I am writing to object to the Mirvac ATP Redevelopment, SSD 15\_7317.

Figure 9 – Building 1 (foreground in white) and Building 2 (background in white)
 Source: FJMT + SISSONS Architects

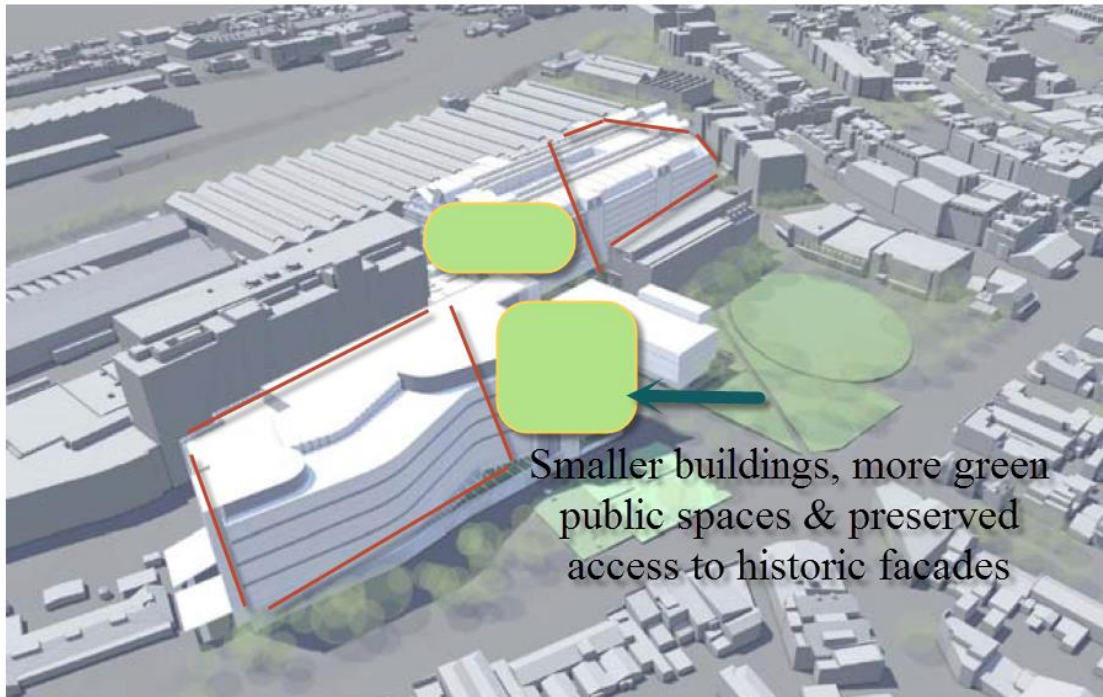
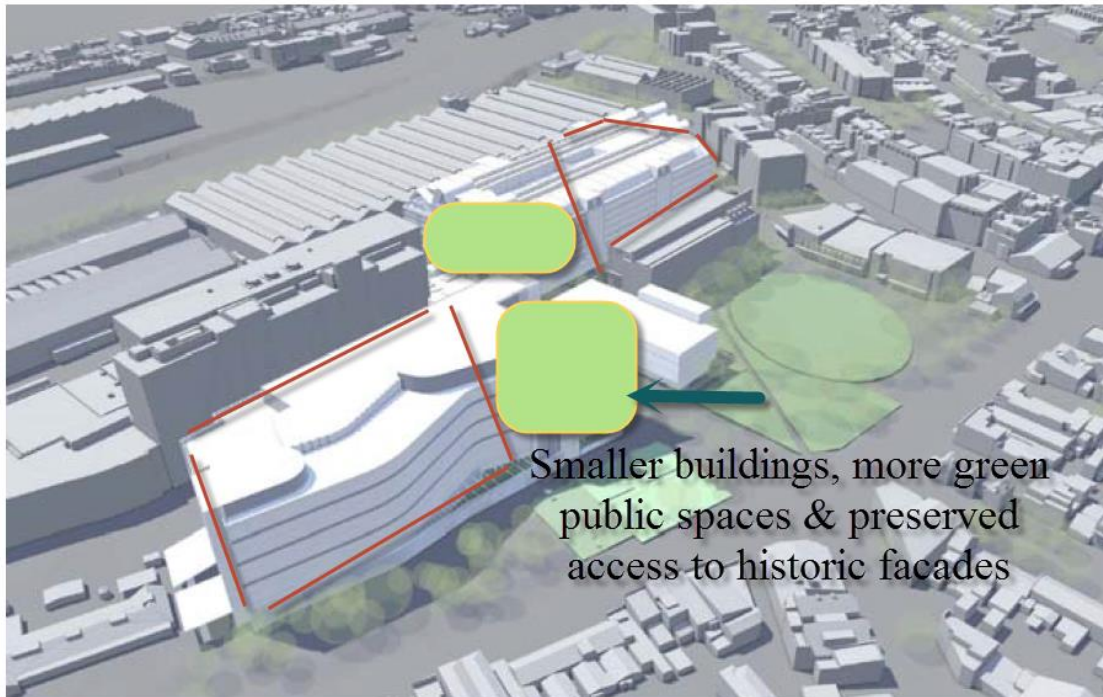
The design of Building 1 seeks a 6.4% increase in GFA and a height increase at the western end from 4 storeys to 9 storeys. This does not consider the impacts on the existing adjoining residential area. The development controls specifically included the 4 storey restriction to ensure a step down to surrounding areas. The proposed design when viewed from the southern side will be huge. The EIS

states there will be panoramic views from the building through the curved glass facade but this glass facade will intrude on the privacy and cause evening light pollution for people living in residential properties to at least 200 metres south of the site. It will also overshadow homes and cause significant light pollution in the evening. Attachment 2 has more detail.

The proposed designs for Buildings 1 and 2 reduce visual amenity within the site and from surrounding areas due to the large footprints. They will block views of the heritage locomotive workshops which are an integral part of the site which demonstrates the important local history.

Alternative designs could resolve the issues I have raised. Building 1 could comply with controls and present a less intrusive impact by reducing western height. The glass facade to the south could be partially screened by something similar to the slats on the current NICTA building to minimise severe privacy intrusions and light pollution impacts on local residents. Visual amenity into the site could be improved if the enclosed outdoor child care centre space was removed. Most of the parking and the child care centre could be relocated to the Community Building if it included a relatively small increase in building height which would still be under the allowable height for the site.
